EN020027 Norwich to Tilbury

Further Submission and Request for Accompanied Site Inspection

IPRN [REDACTED] – Aldham Parish Council

Colne Valley Landscape – Fordham/Fordstreet, Aldham

**Appendix E
Action Point 27 –
Colne Valley
(including Fordham,
Ford Street, Aldham)
Constraints and
Opportunities Plans**

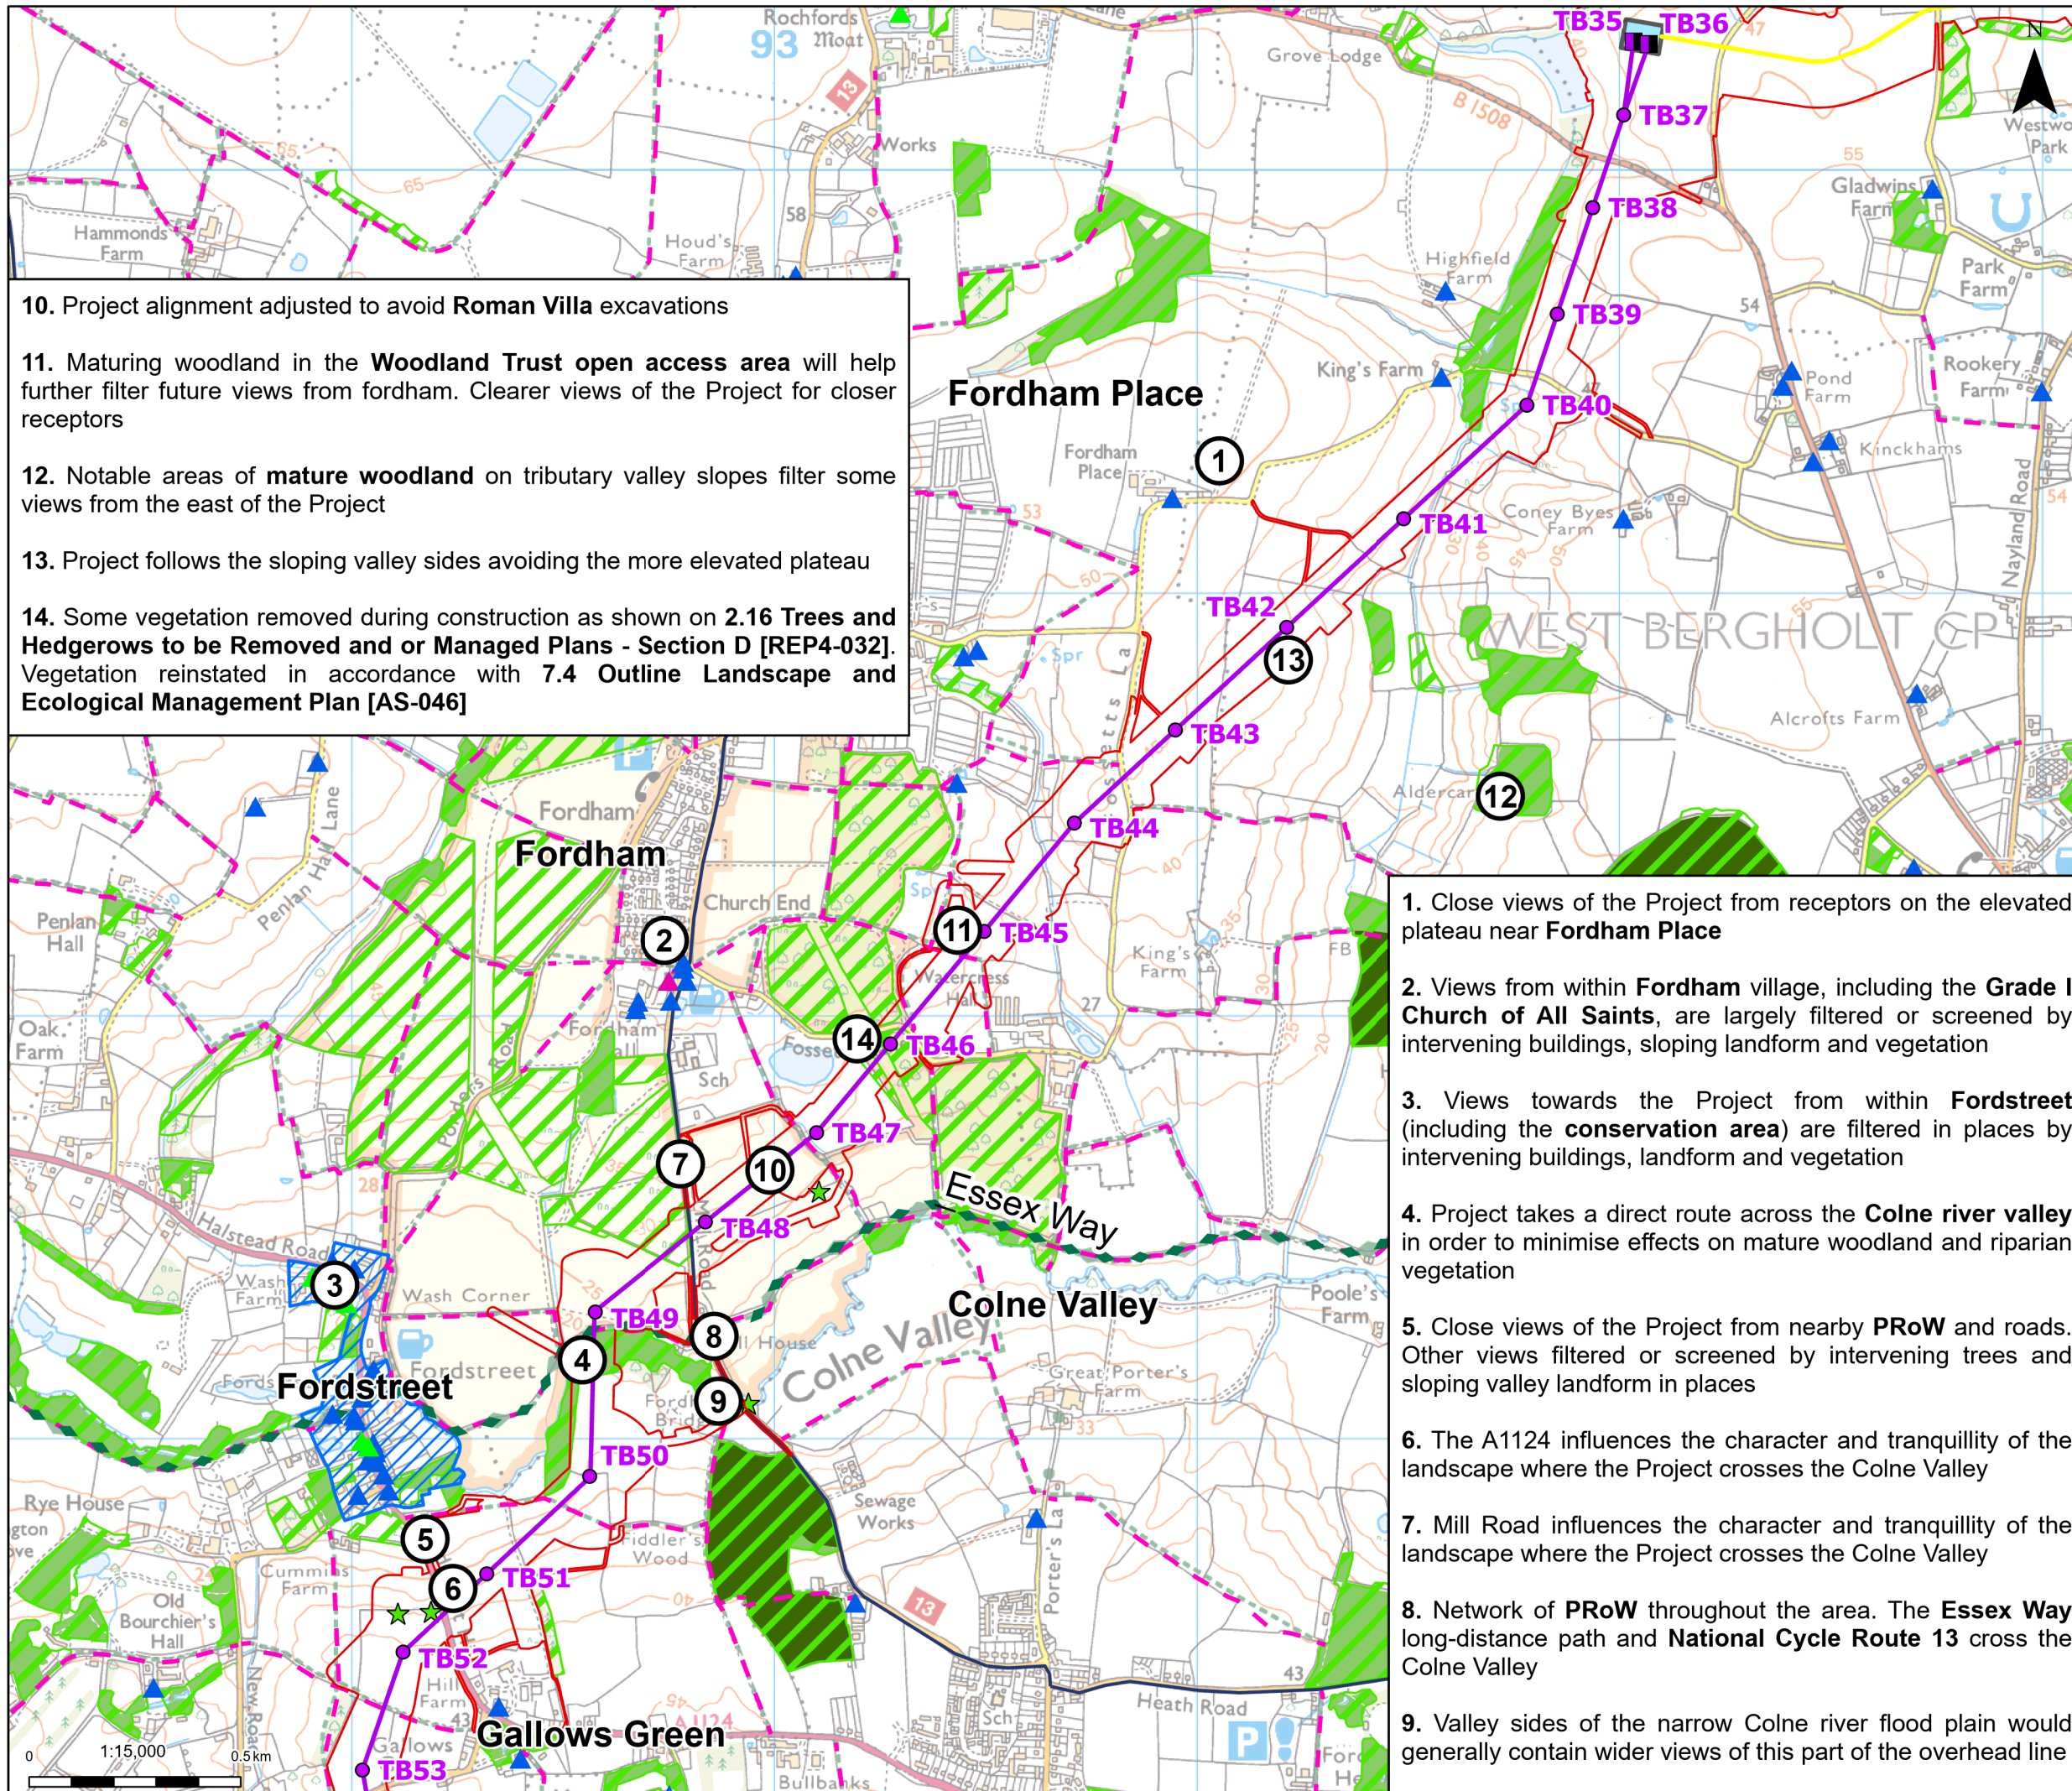
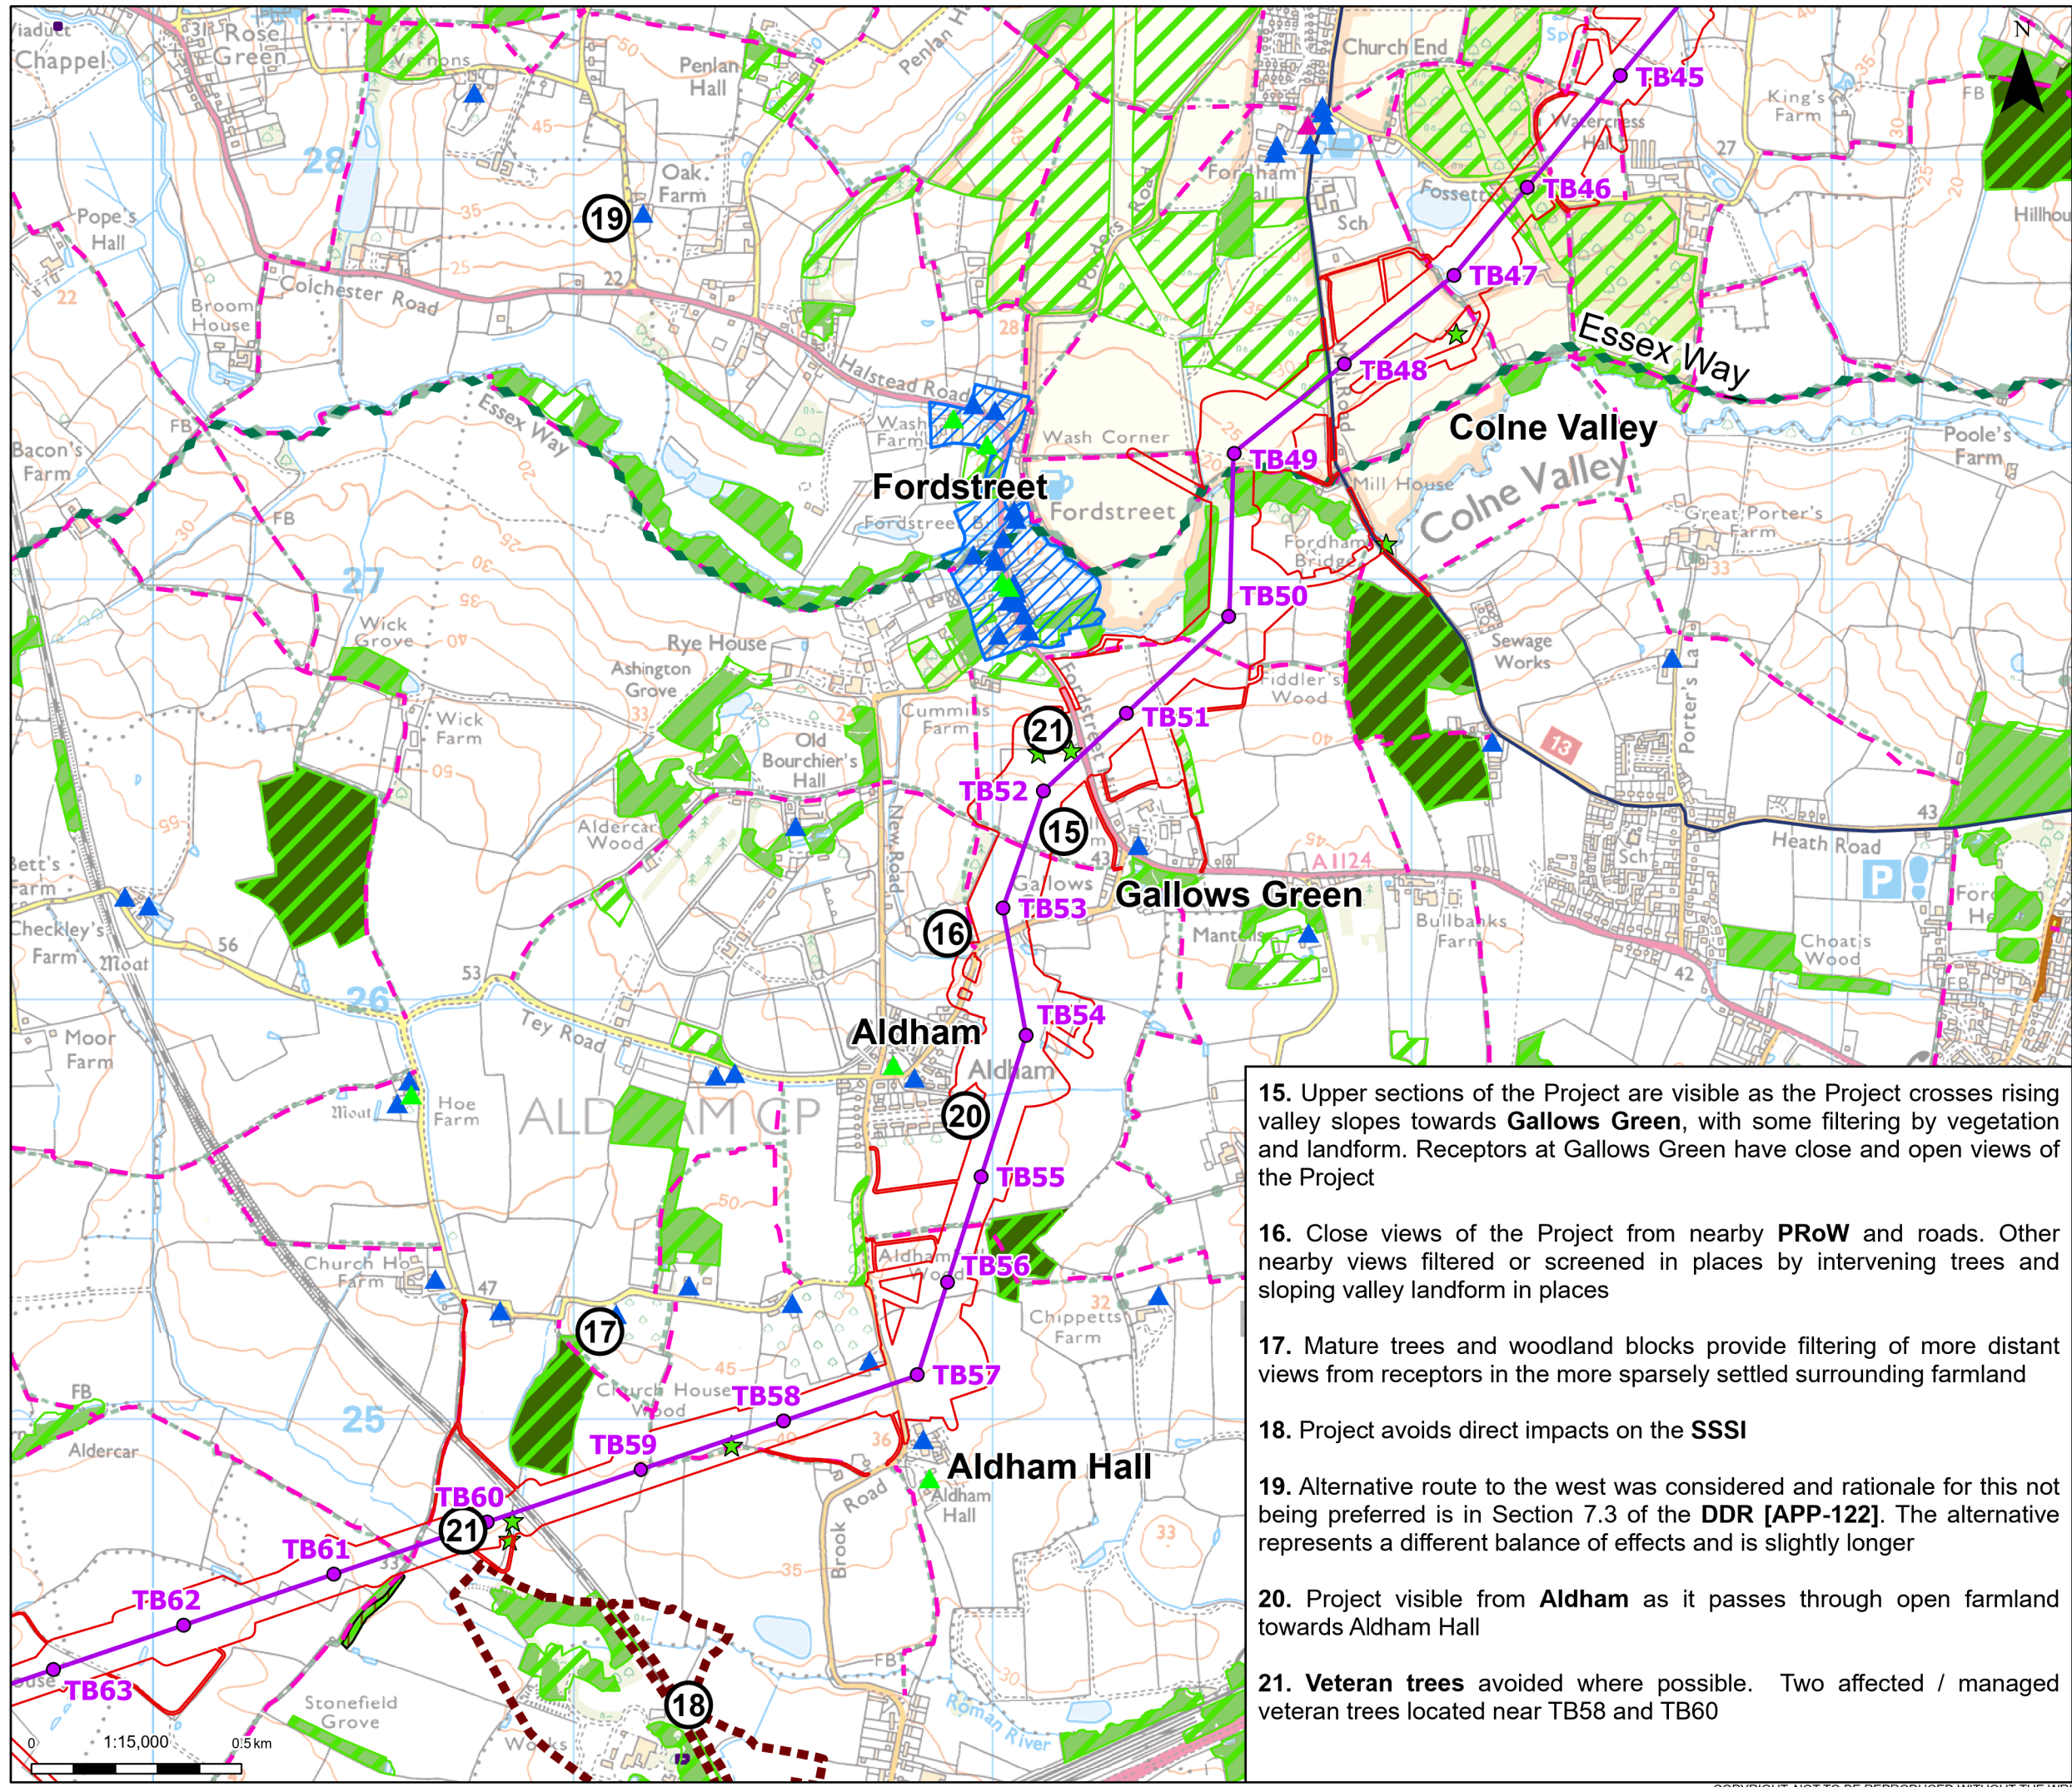
The Applicant has not provided Masterplans, but limited sketch maps; and certainly no “agreed position in terms of compensation measures”. It is clear from the Opportunity (see below) and Constraint Maps provided at Appendix E in answer to Action 27 (see above) that the suggestions are inadequate or incorrect. There is a mismatch between what the ExA requested and what the Applicant provided.

It is also clear, as you will see from the notes below, that neither Parish Councils nor local landowners have been consulted. These maps are vague and appear to be very superficial desktop surveys. This can be assumed to be the case across the entire route.

There are only two veteran trees shown on the South Constraint Map, but they appear to be in the wrong place. There are two at the bend in Tey Road. [See list below from Woodland Trust map of relevant existing trees].

- The Applicant suggests part of Rectory Road, Aldham could see 'connective green infrastructure enhancements' but it is already a quiet country lane with mature hedgerows.

- Ditto they show that New Road, Aldham offers the same opportunity, but this road also already has mature trees and hedges all along it.
- The Local Nature Recovery Strategy also covers the Colne Valley maps, while the Applicant employs meaningless arrows.

- The map fails to show the Roman River Corridor, which is shown in Colchester's Draft Local Plan as both an Essex LNRS nature opportunity and as green/blue infrastructure.

- The Woodland Trust already manages the area for scrub and woodland
- Likewise, the Applicant proposes 'connective green infrastructure' on the Fordham Estate. The Woodland Trust already manages for habitat connectivity, meadowland, woodland, heritage, public access and recreation.

- They recommend tree planting where planning permission for 150 houses is granted.

the maps for Fordham and Aldham show at least 5 veteran trees and a couple of notables that will soon become veterans are missing:
